# Rezoning Transportation Analysis

Petition Number: 2020-155

General Location Identifier: Tax ID: 20103222

Date	Description
11-30-2020	First Review (KP)
12-28-2020	Second Review (KP)

DATE	August 31, 2020
SCALE	1" = 30'
JOB NO.	20200807
SHEET	RZ-01

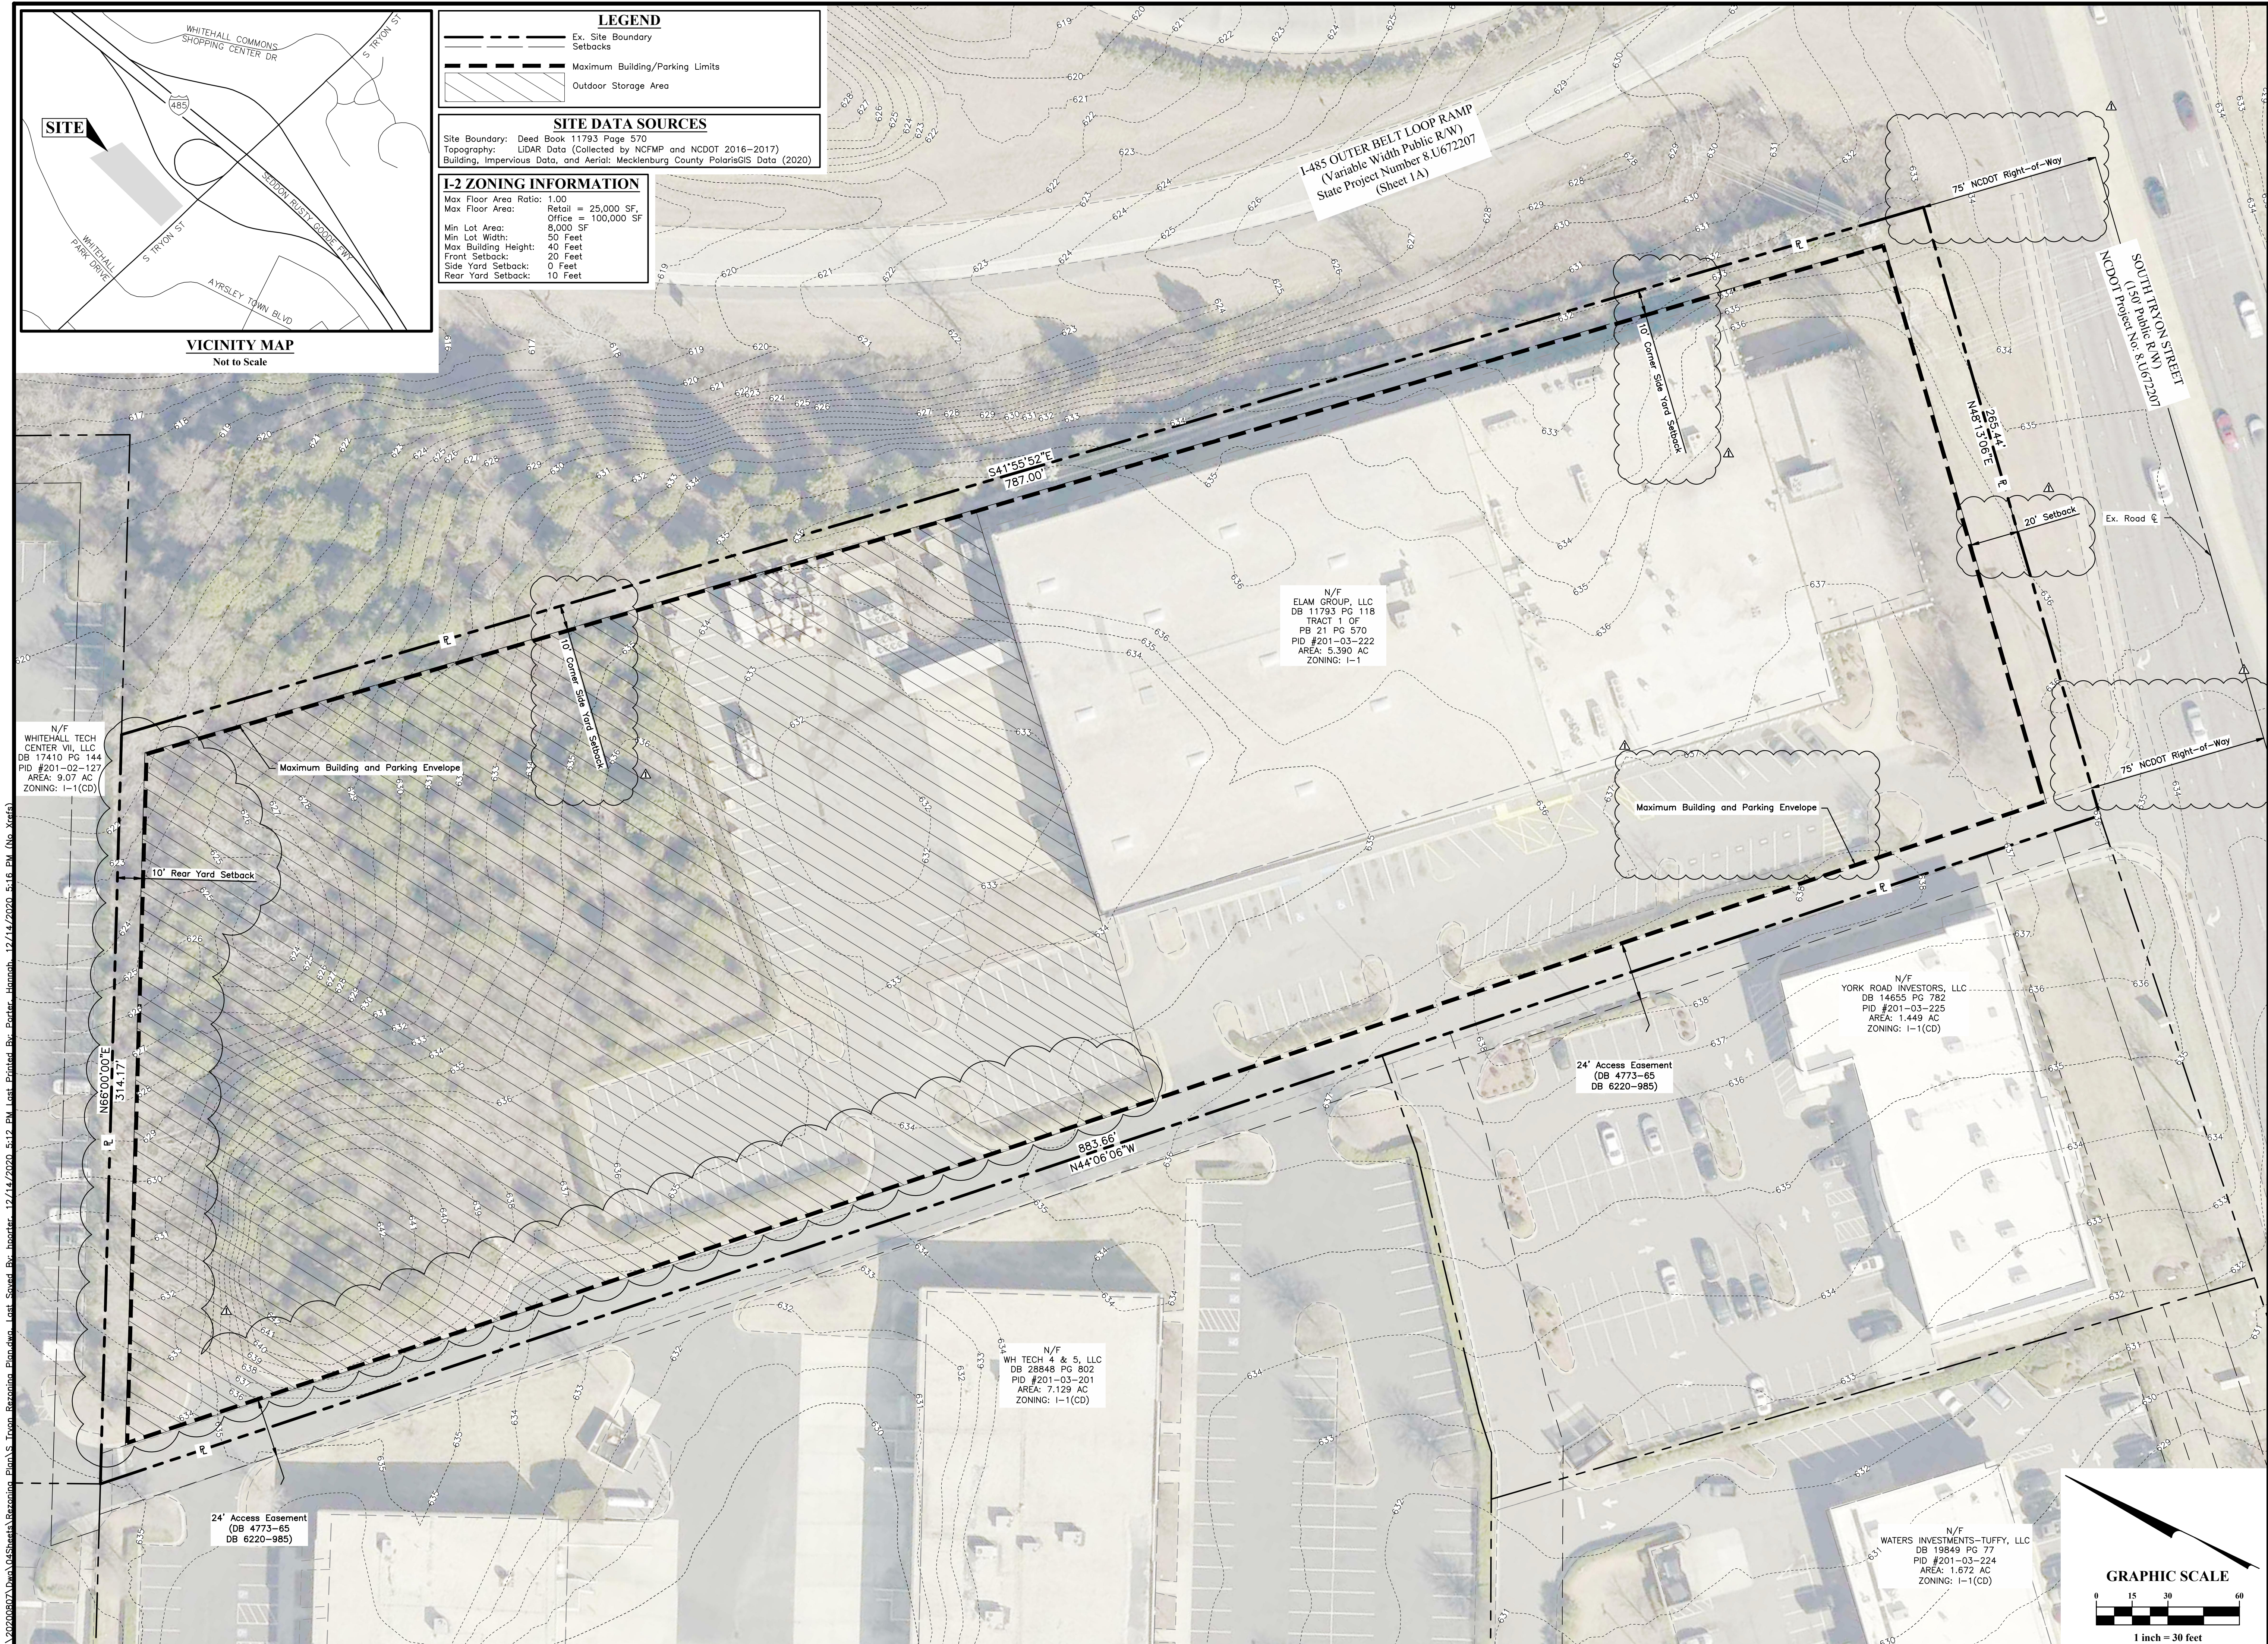
~~Label and dimension the future curb and gutter from the centerline to back of curb.~~

Note has been added to work with NCDOT during permitting regarding any site modifications.

SHEET
RZ-02

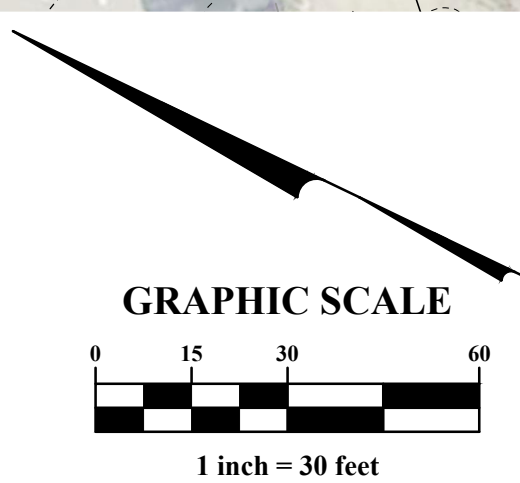
5. A site plan note(s) specifying dedication and fee simple conveyance of all rights-of-way to NCDOT before the site's first building certificate of occupancy is issued is needed. CDOT requests rights-of-way set at 2' behind back of sidewalk where feasible.

**Update to comment as a result of the 12-15-2020 Site Plan: Note 3.C states "...City of Charlotte...", needs to say NCDOT.**
